Planning Application Ref: BE/180/16/PL (3) Updated comments appear in blue typeface – 18.04.17

Location: Land adj. to 2 North Bersted Street, Bognor Regis

Description of works: Construction of 1 No two storey dwelling on a narrow storage yard

SITE PLAN
SCALE 1:200

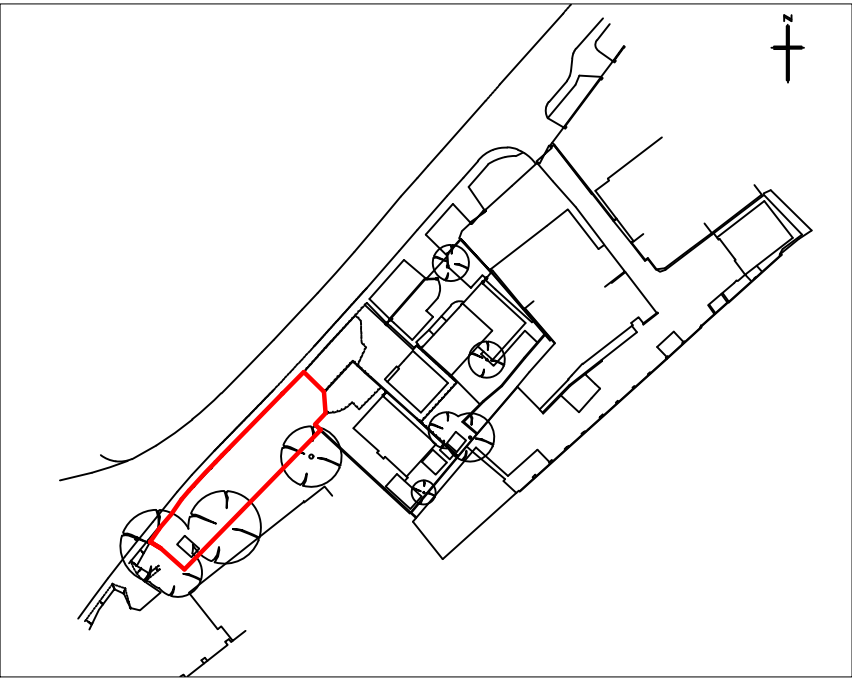
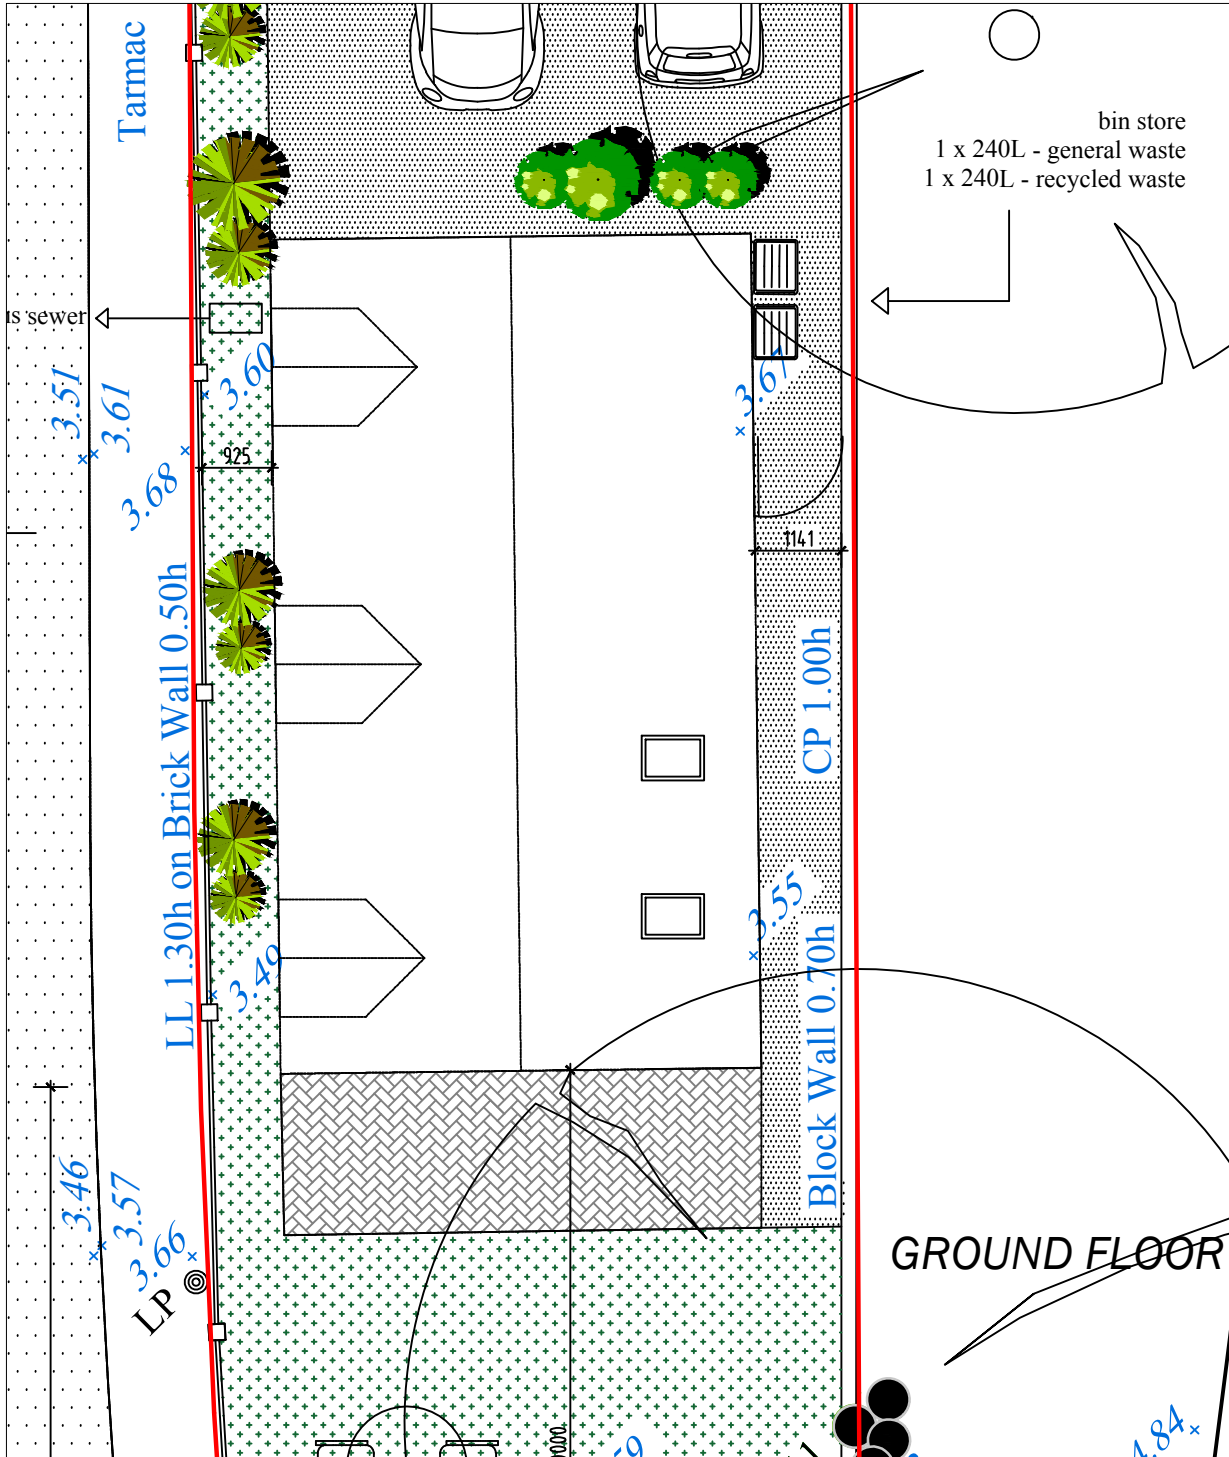
The supplementary picture of the south east edge of the as site posted on the planning portal (enc below) demonstrates how the low eaves building proposed can be constructed without trimming the trees. The proposed building overlaps the furthest extent of the canopy of one tree by about 1M but, as can be seen from the photograph, the tree in question has a base some 750mm above the FFL of the proposed building and has a tall and ragged canopy. The eaves of the proposed building will easily fit below the plastic bag shown caught in the canopy meaning that no trimming will be required.

If you do not cut the overhanging branches back they will directly overhang the roof and guttering of the new dwelling casting shade and at certain times of the year filling guttering with leaves potentially blocking downpipes.

Tree Constraints Plan
North Bersted Street, North Bersted, Bognor Regis

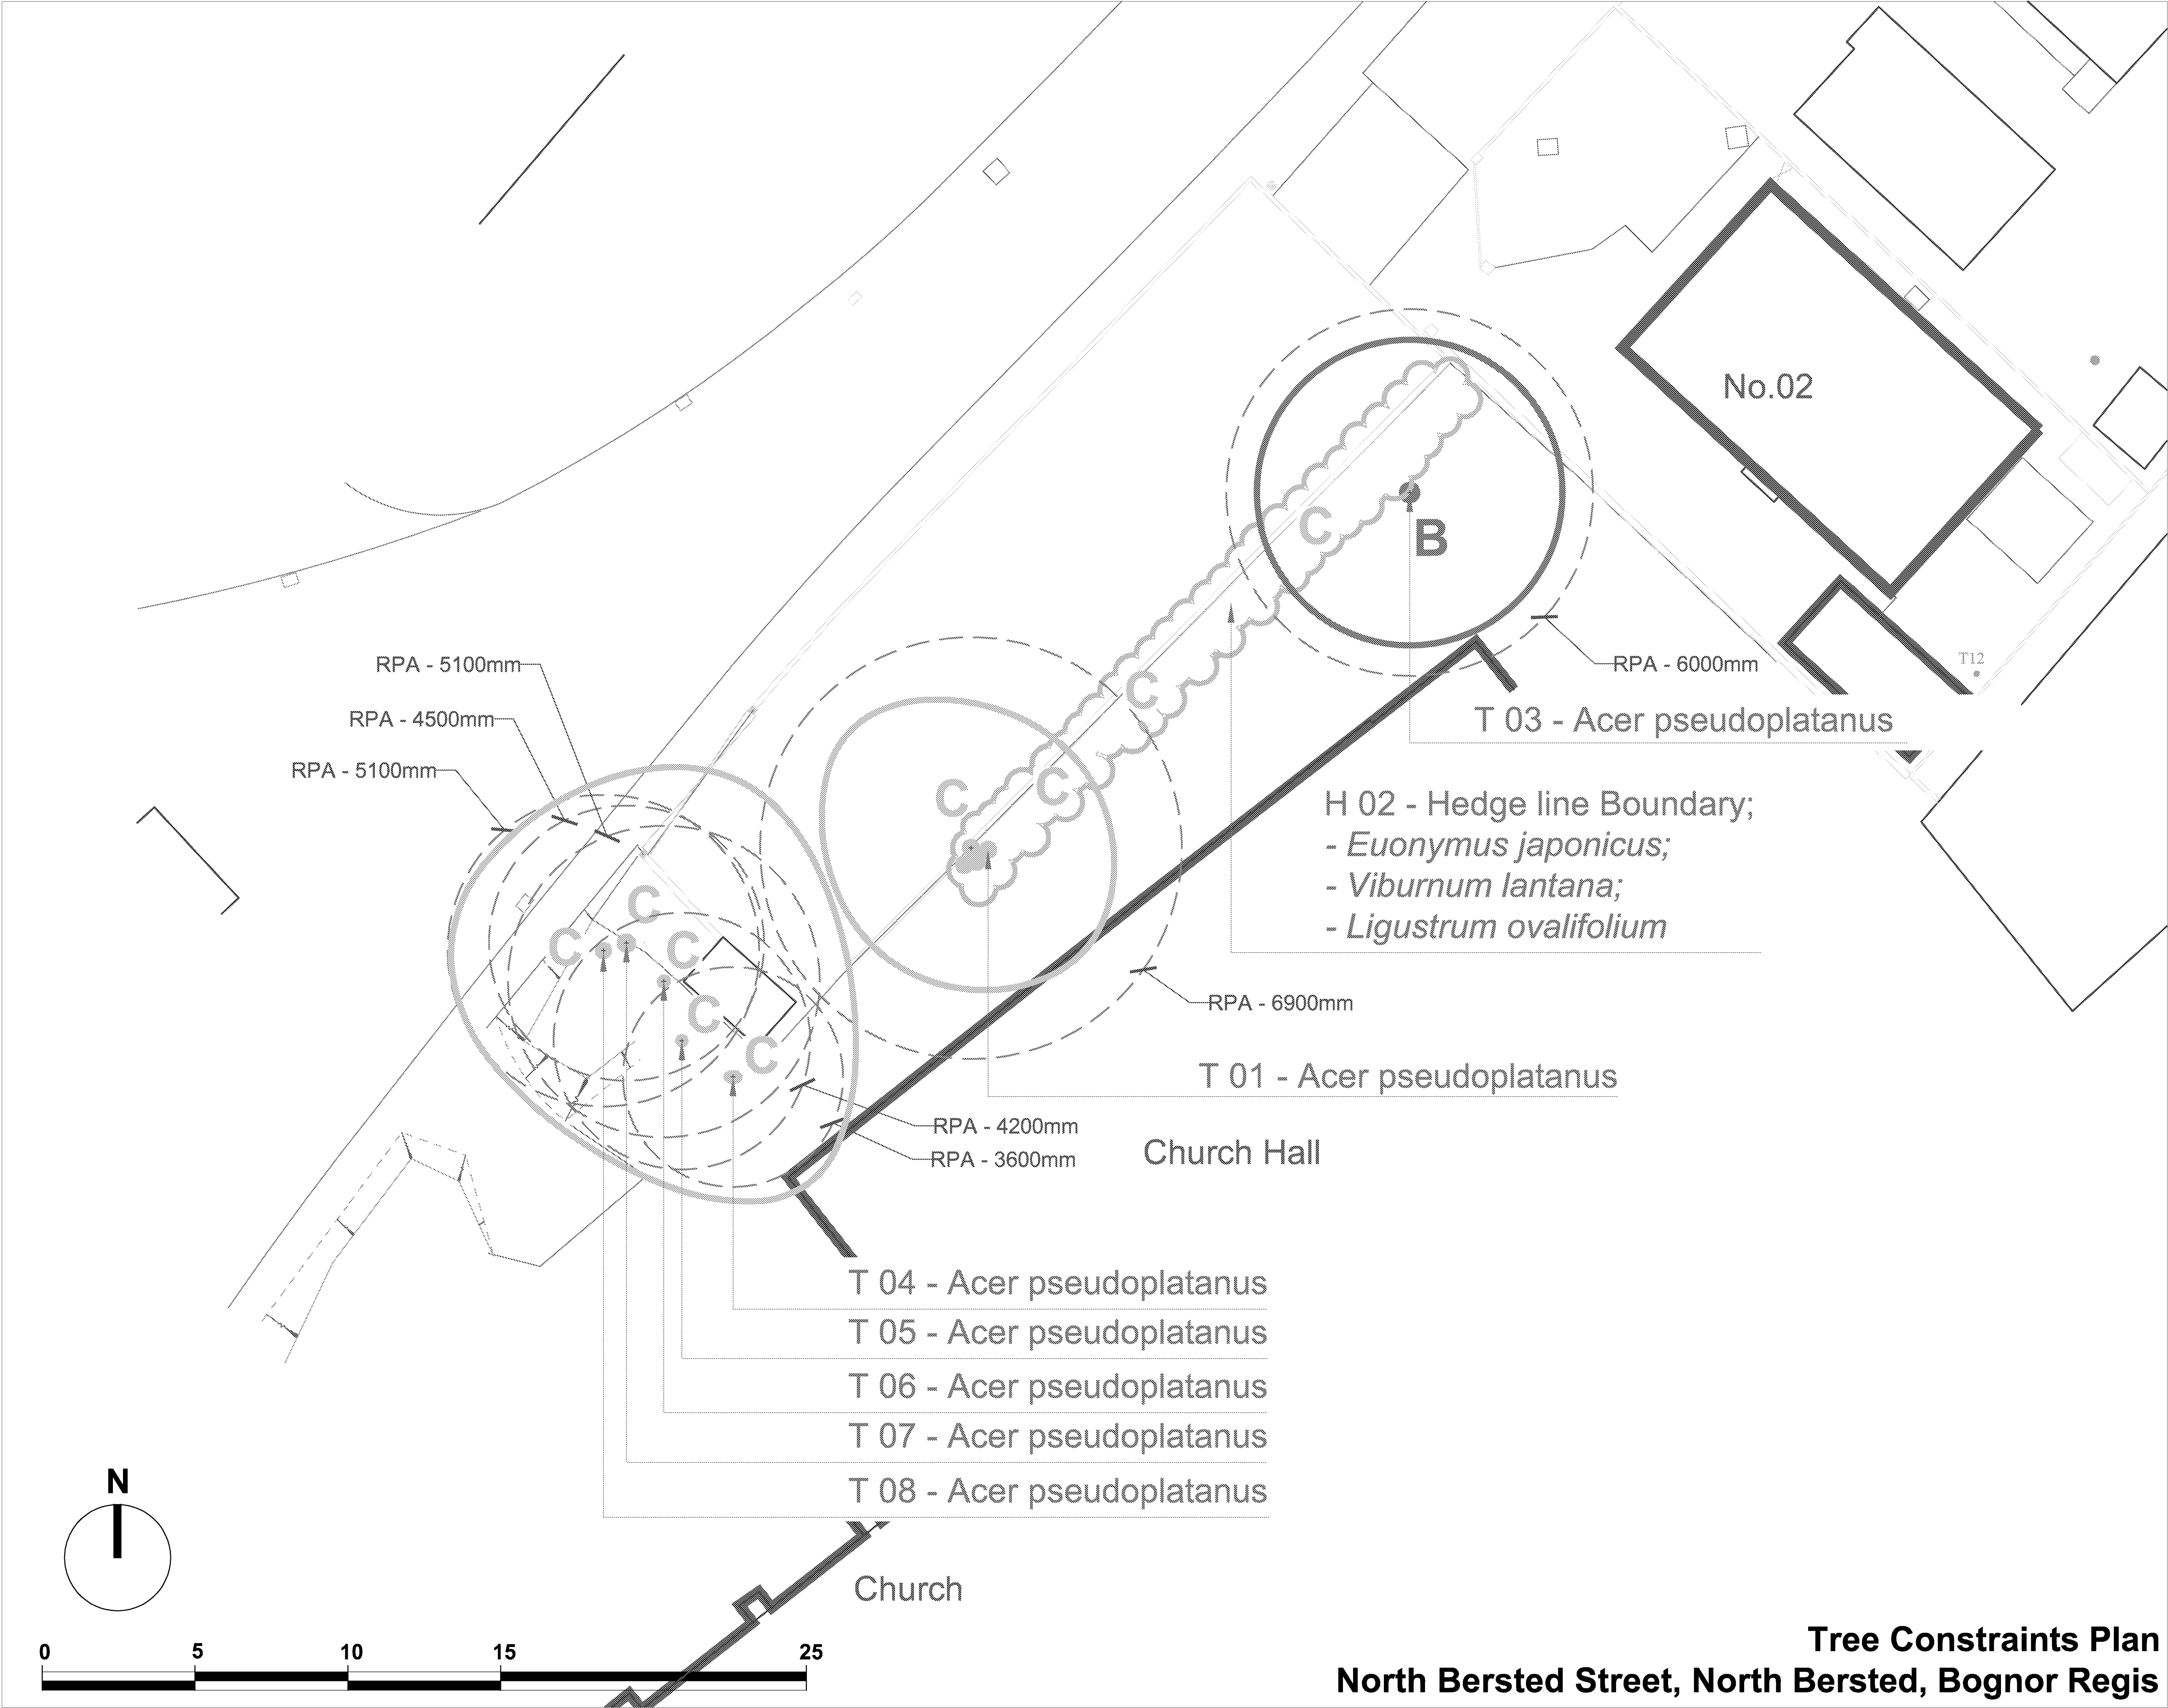
It is true to state that these Sycamore trees are self-seeded and not of a quality whereby we might want to place them under a Tree Preservation Order - nevertheless they exist and BS5837:2012 requires that we take them into consideration in the light of any proposal to develop in close proximity – overhang of branches is not the only consideration here as they are positioned to the south side of the development site and thus will cast heavy shade across the house and garden. They are also young trees with significant growth potential so as they grow and their crowns eventually meet up along the boundary line there will be a solid screen of leaves and branches and even more intense shading of the garden.

My objection is about the overall relationship of house to trees and the sustainability of development on this plot – I accept that constructing a dwelling here is possible but it is the ongoing relationship between trees and house owner that leads me to conclude that there will inevitably be pressure to 'prune or fell' these trees – which equates to poor planning and design.

Sycamore have a propensity to readily seed into open ground and this is likely to lead to conflict when a new garden is proposed within the direct 'drop zone' of these seeds which will be a cause of constant irritation for the new owners. Additionally we have the problem of aphids feeding on the leaves and excreting sticky sugary sap that drips from the trees in the Summer months adhering to paintwork and paths and patio surfaces as well as garden furniture and also washing hanging out on the line – resulting in discolouration and damage.

- As things stand I would have to sustain an **OBJECTION** to this scheme as I feel that the relationship of trees to dwelling would inevitably lead to conflict and ‘pressure to prune or fell’ these trees. In essence it boils down to the fact that in my opinion trees and dwelling cannot exist in harmony here so you either have one or the other but not both.
